Application for a Non-Material Amendment Following a Grant of Planning Permission

Number	2
Suffix	
Property Name	
Address Line 1	Hatherleigh Road
Address Line 2	
Address Line 3	Hillingdon
Town/city	Ruislip
Postcode	HA4 6AS

ground and first floor side and rear extensions to house

76449/APP/2021/4505

scale: 1:50 + 1:100	job: 3313
date: Nov 21	
drawn:	dwg. no: 11B
client:

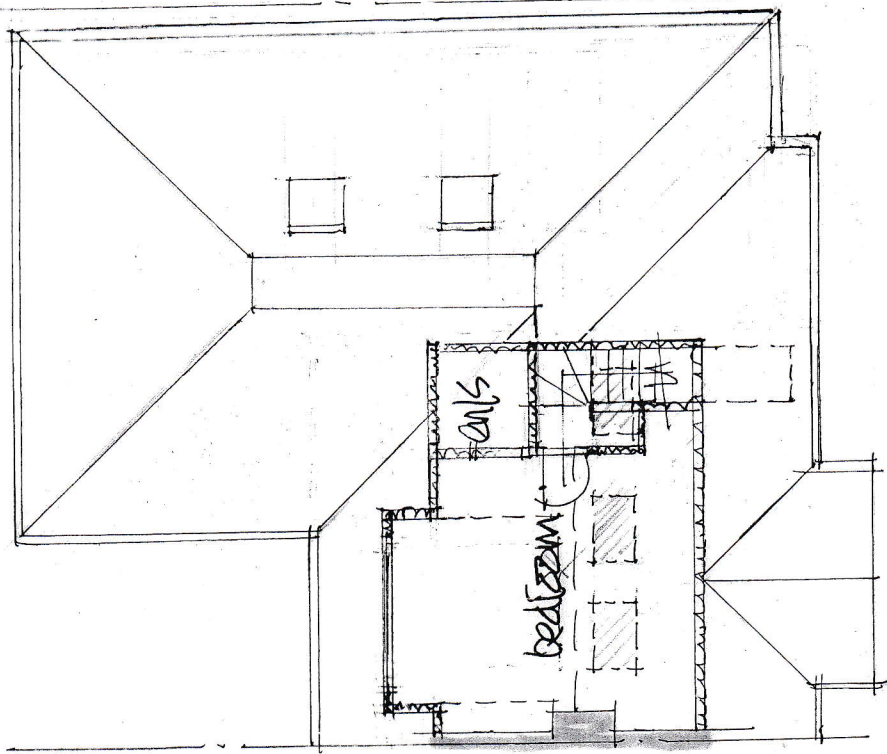
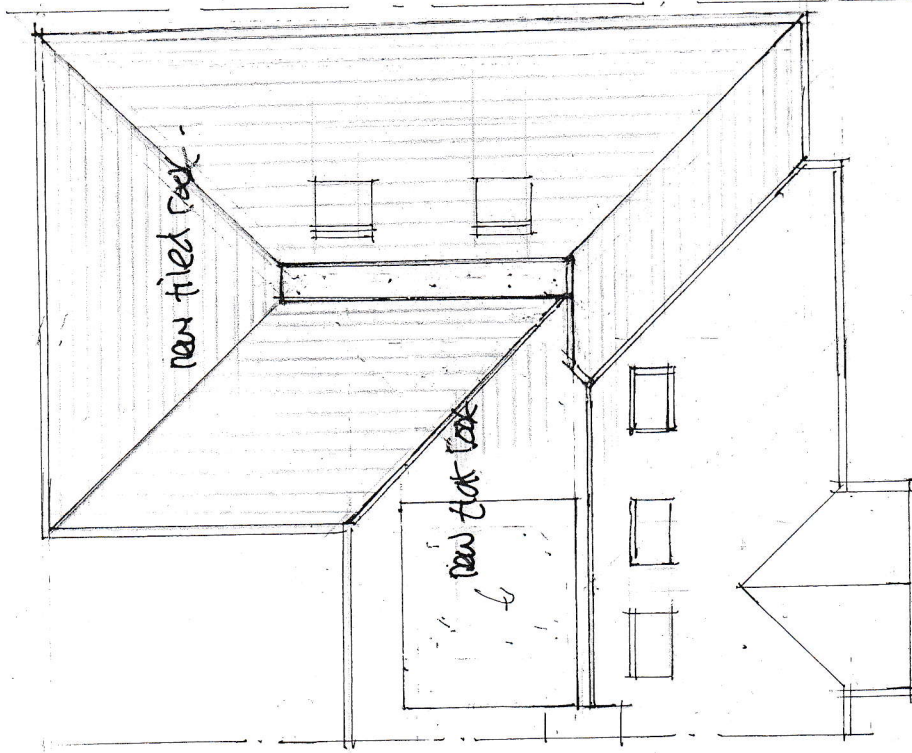
one additional velux to front elevation,extension of ridge line,2 velux added to side elevation and omission of one first floor window,minor revision to windows to rear elevation and increase in with of rear dormer by 400mm.
